Item No.	Report of the Head of Development Management and Building Control
Address:	THE BARN HOTEL WEST END ROAD RUISLIP
Development:	Redevelopment of the site for residential use involving the partial demolition of the existing Grade II Listed Building and conversion to 2 new residential units, demolition of surrounding buildings and erection of 2 new residential blocks with associated amenity space, landscaping and parking
LBH Ref Nos:	7969/APP/2023/1473

**Drawing Nos:**

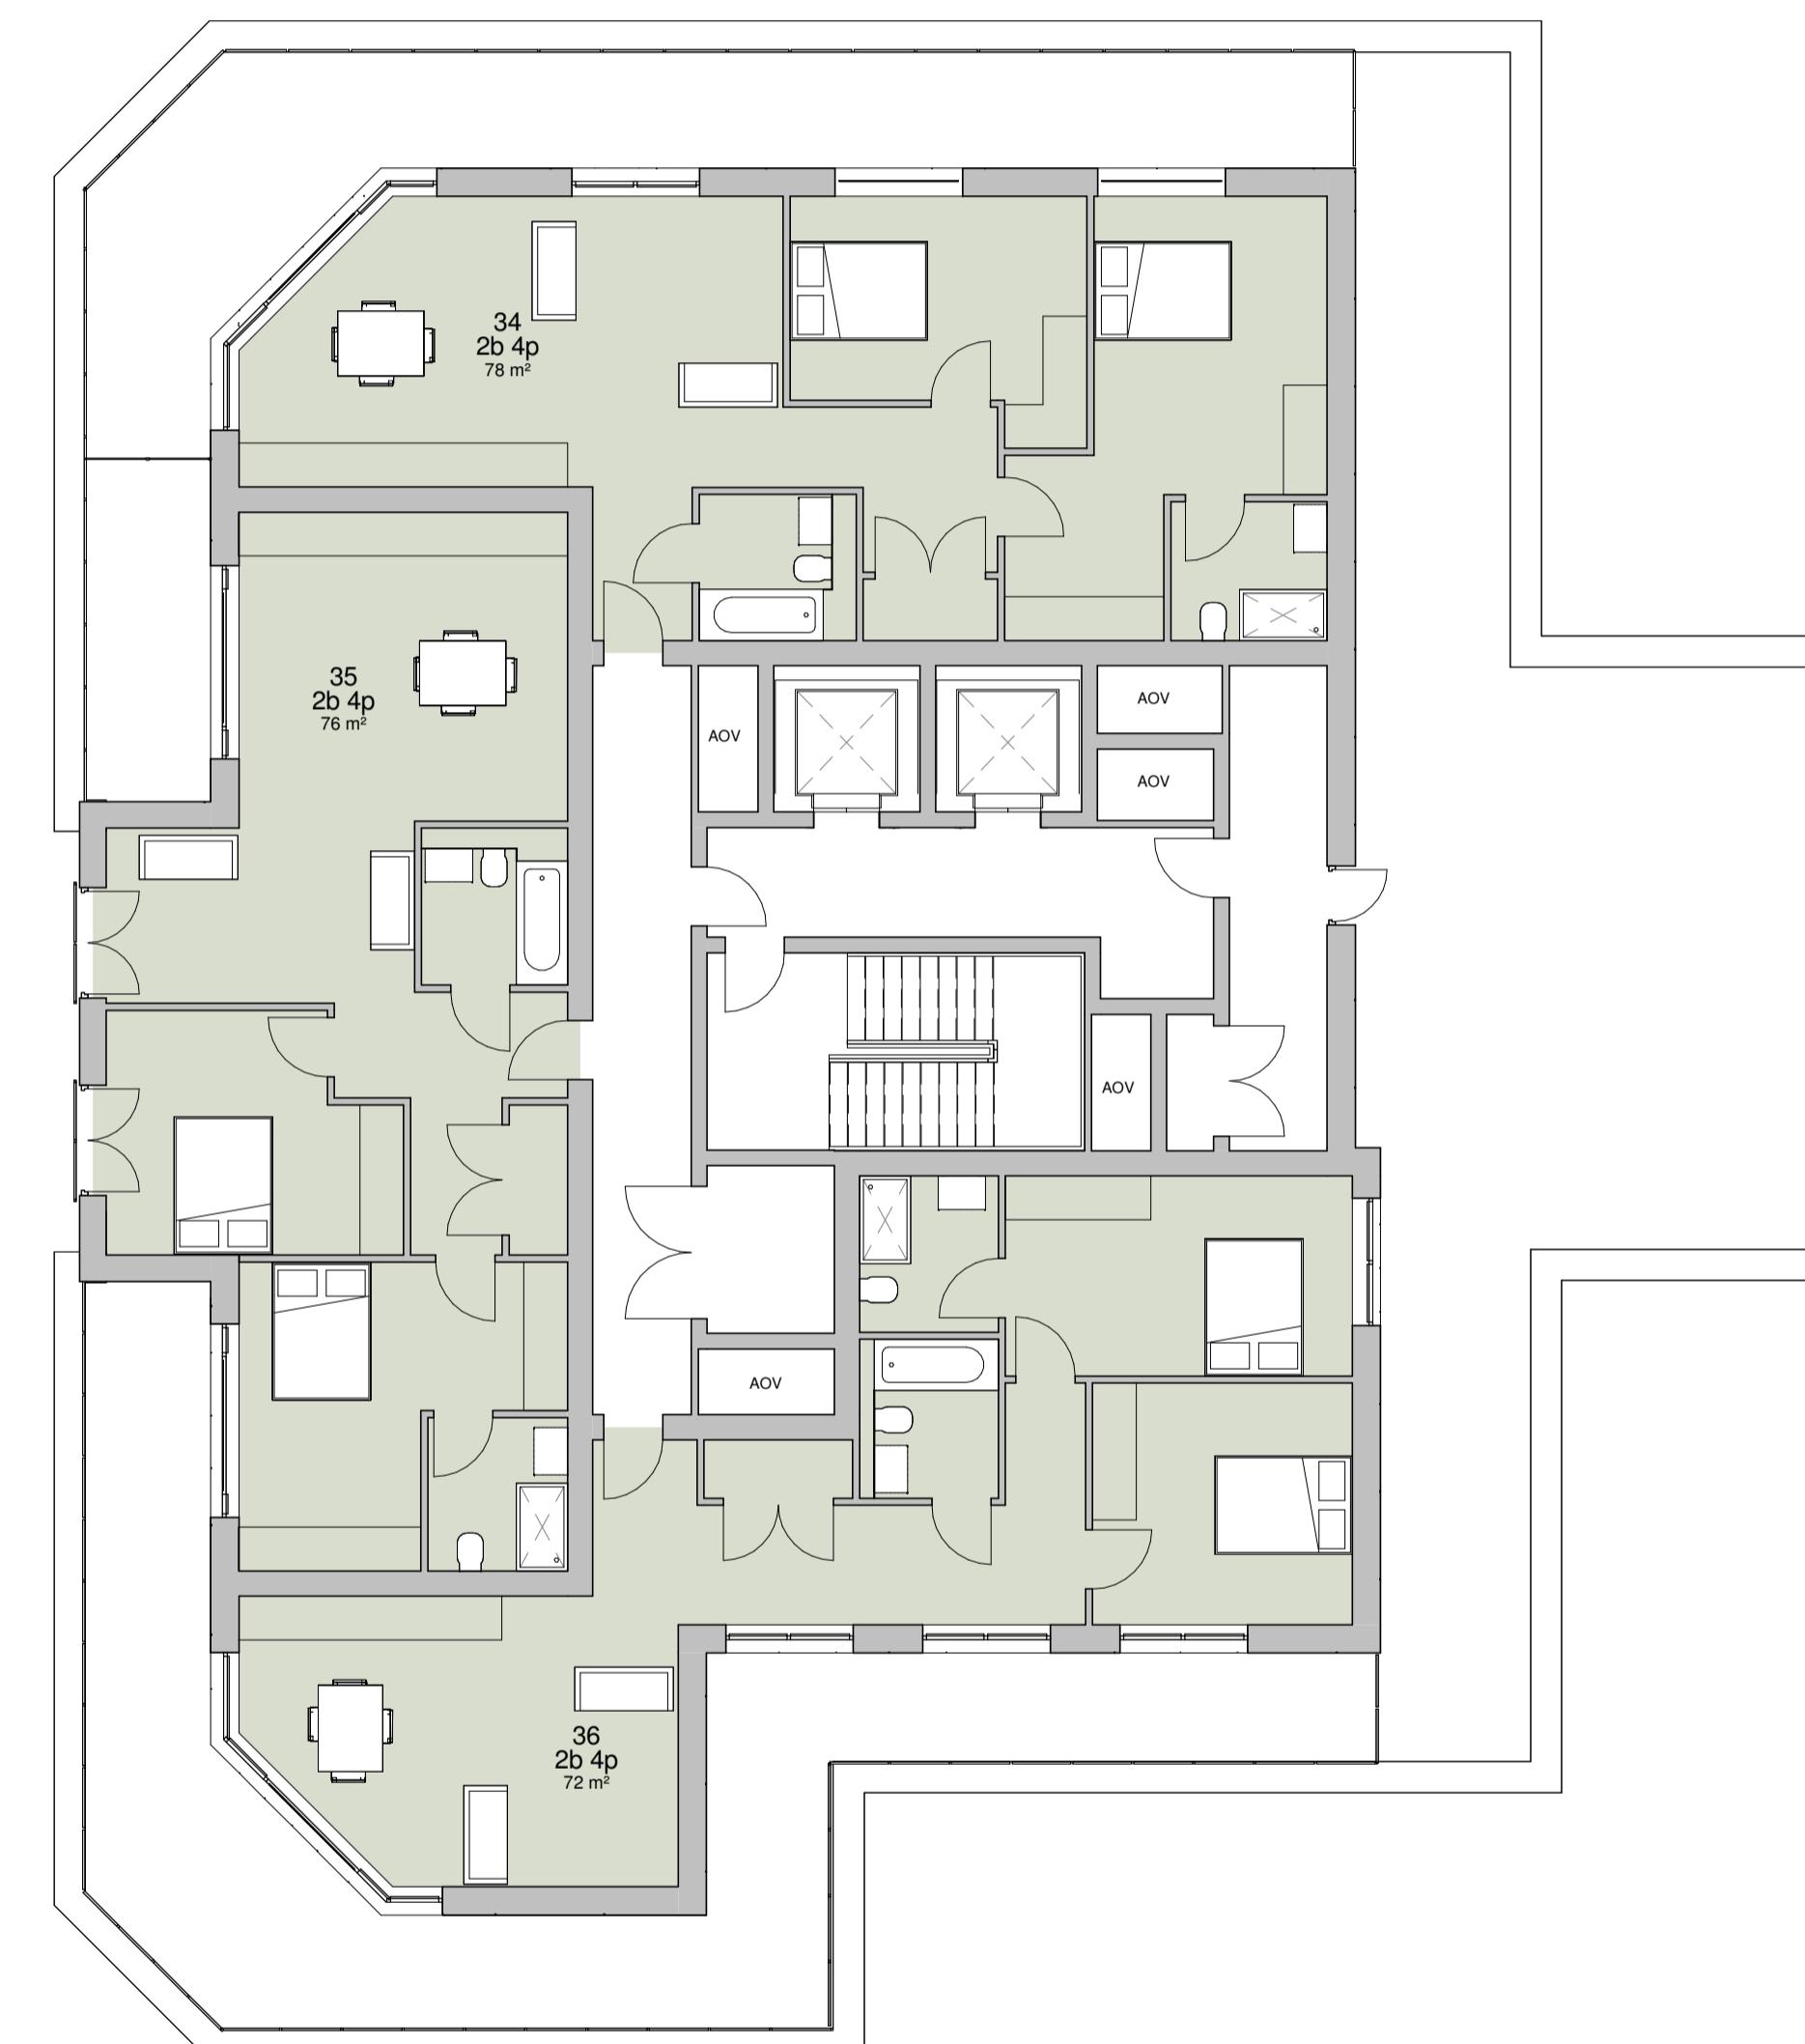
3.2.6 A drafting error is noted on drawing ref 22 0063-203 F where the fifth floor plan does not illustrate access to the roof terrace presented on the corresponding elevations. Notwithstanding this drafting error, the applicant has confirmed that the space would be accessible to the upper floor units and if minded to approve the application, a condition could be used to secure a revised floor plan. As such, the area has been included within the amenity space calculation.  
Total: 1786 sqm
